Our Ref: TR020005

Date: 3 August 2023

Application by Gatwick Airport Limited for an Order Granting Development Consent for the Gatwick Airport Northern Runway project

Advice following issue of decision to accept the application for examination

Title:
Special Category Land Plans - APFP Regulation 5(2)(i) - Sheet 1 of 1

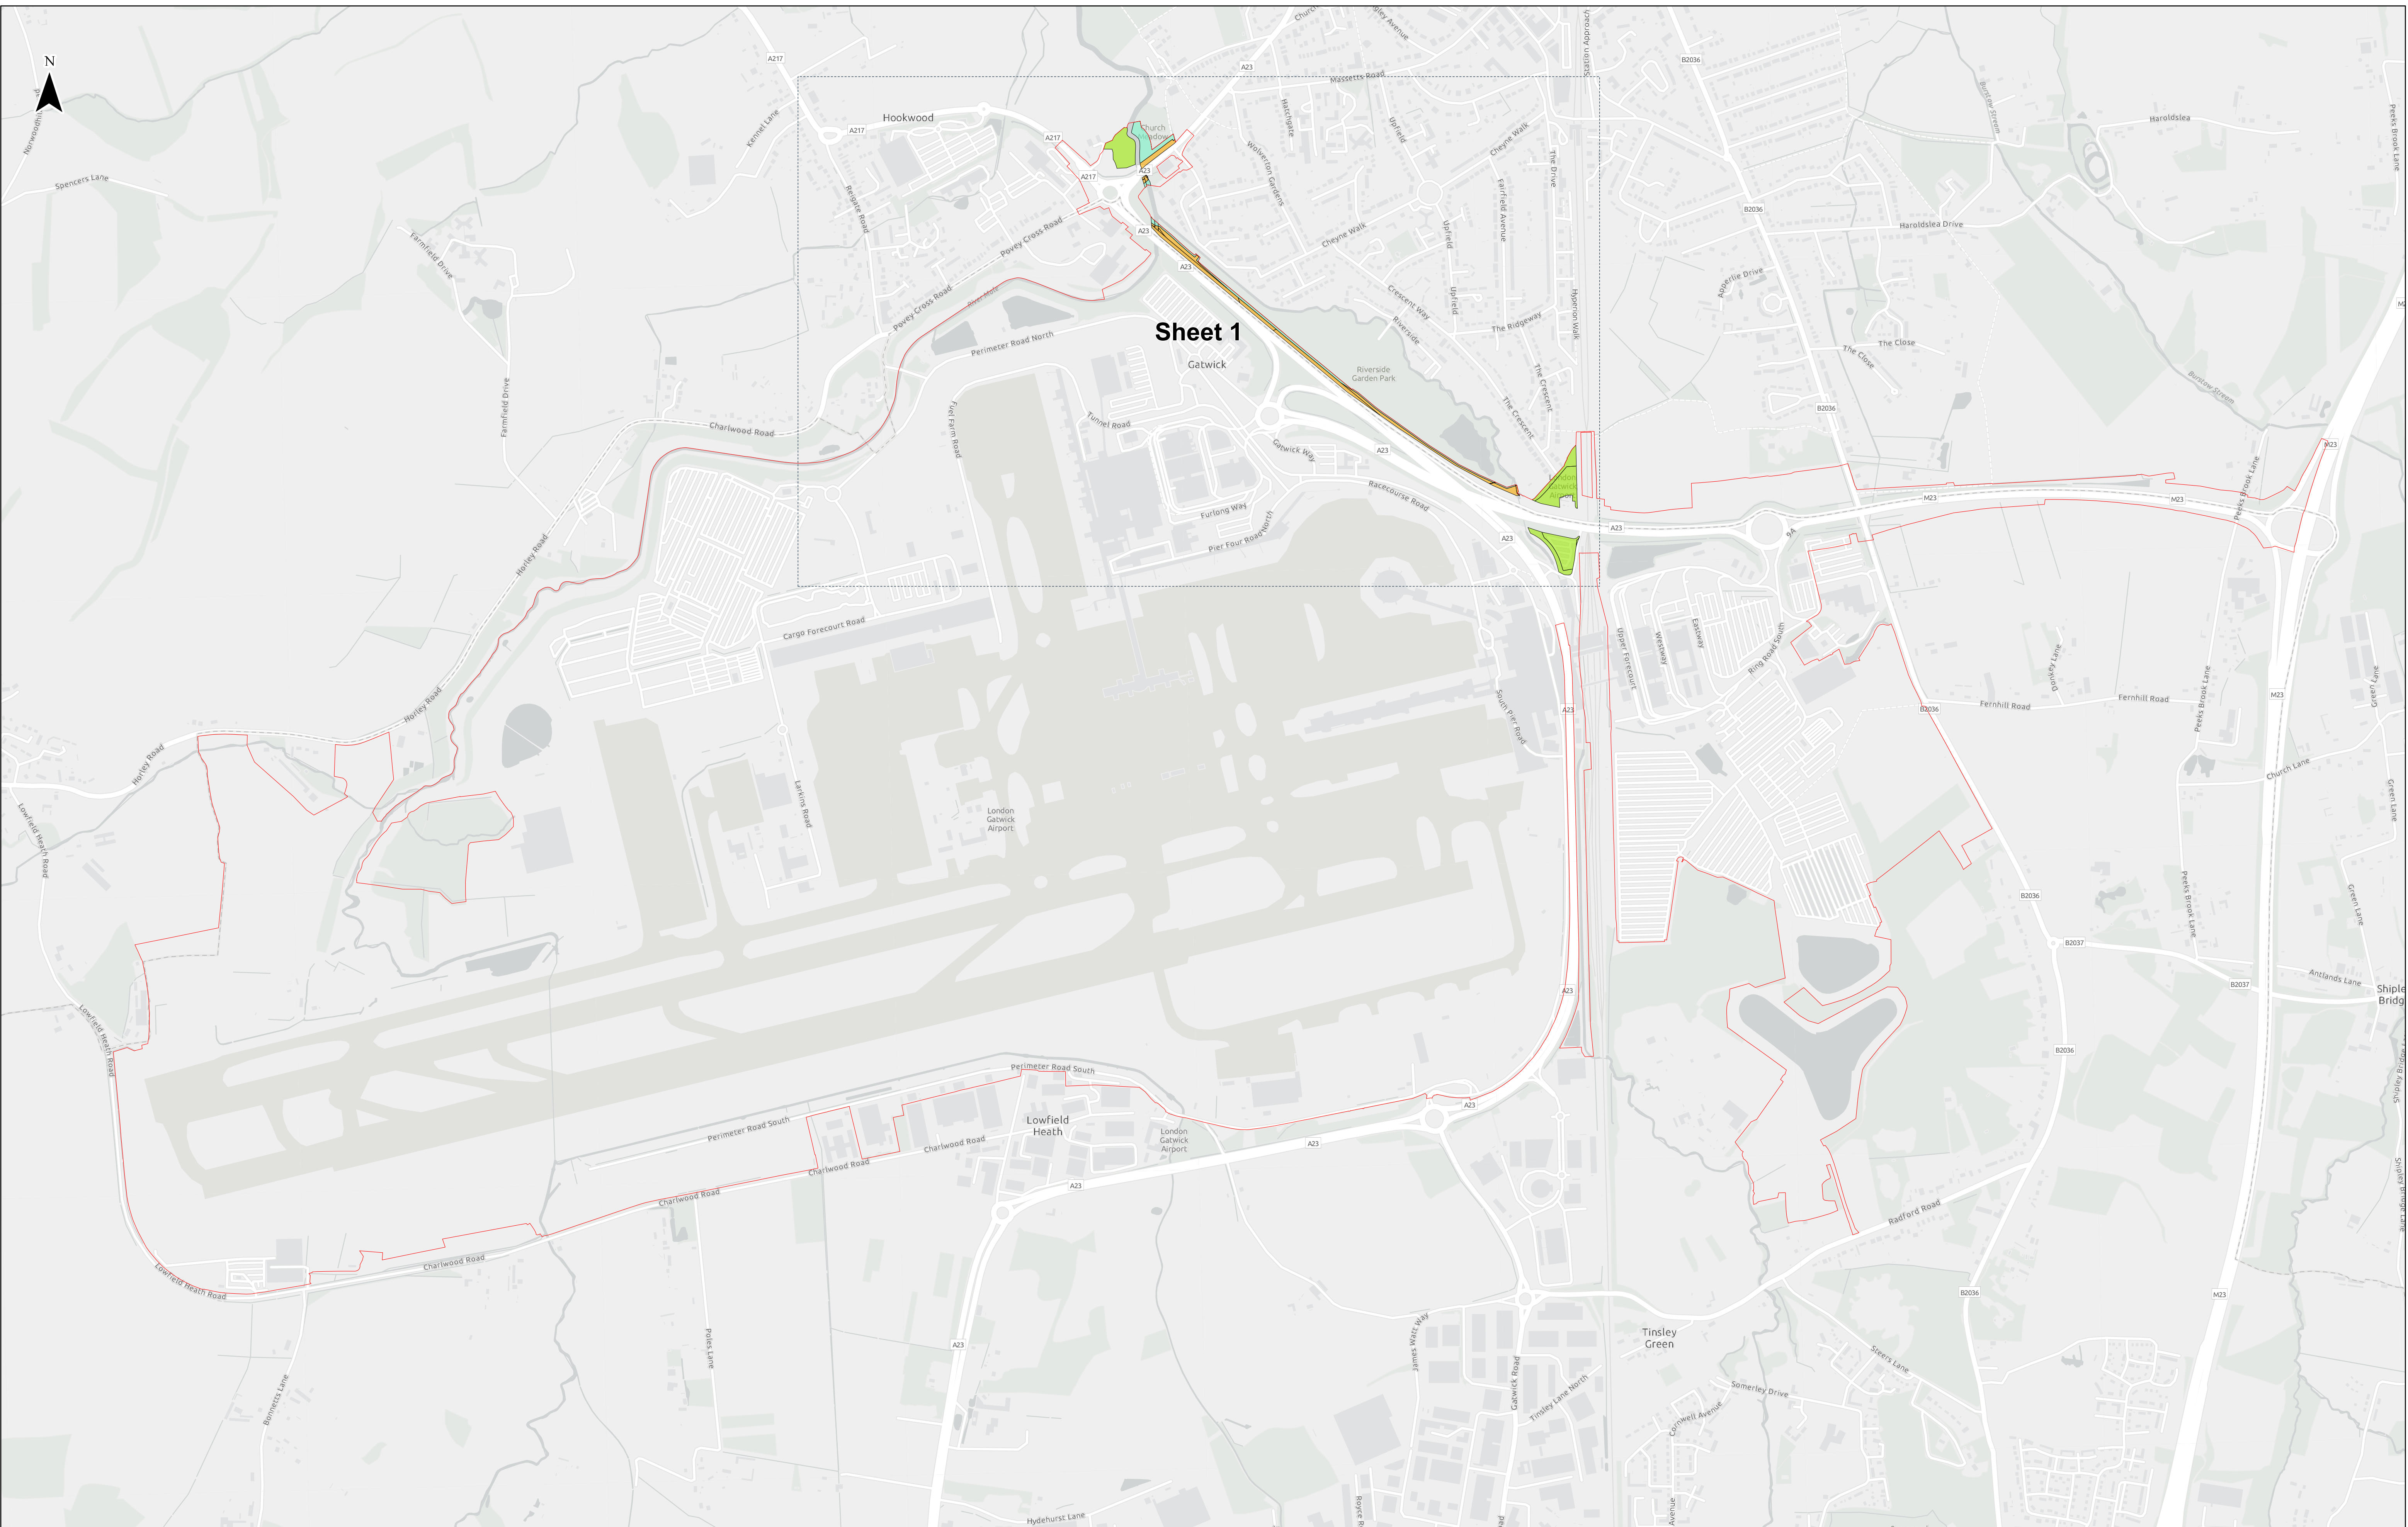
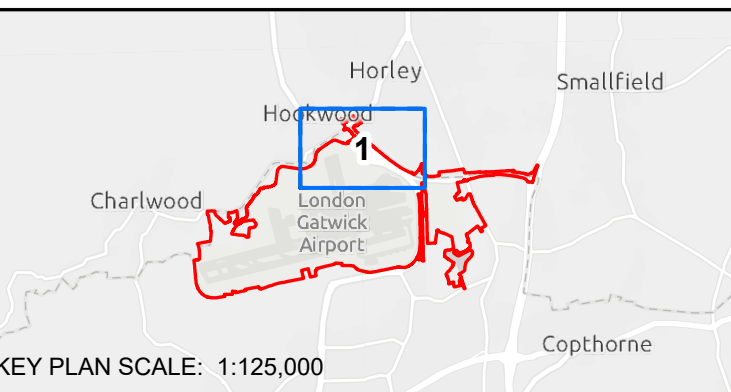
As noted in Box 30 of the s55 checklist, the Land Plans (Doc 4.2) and Special Category Land Plans (Doc 4.4) are unclear in places due to a lack of plan insets and drawing anomalies. The Applicant should review the plans in detail to address the specific examples highlighted in the checklist and identify any similar issues. Updated plans including insets should be provided where appropriate. The Applicant should also consider where general improvements to readability and clarity can be made.
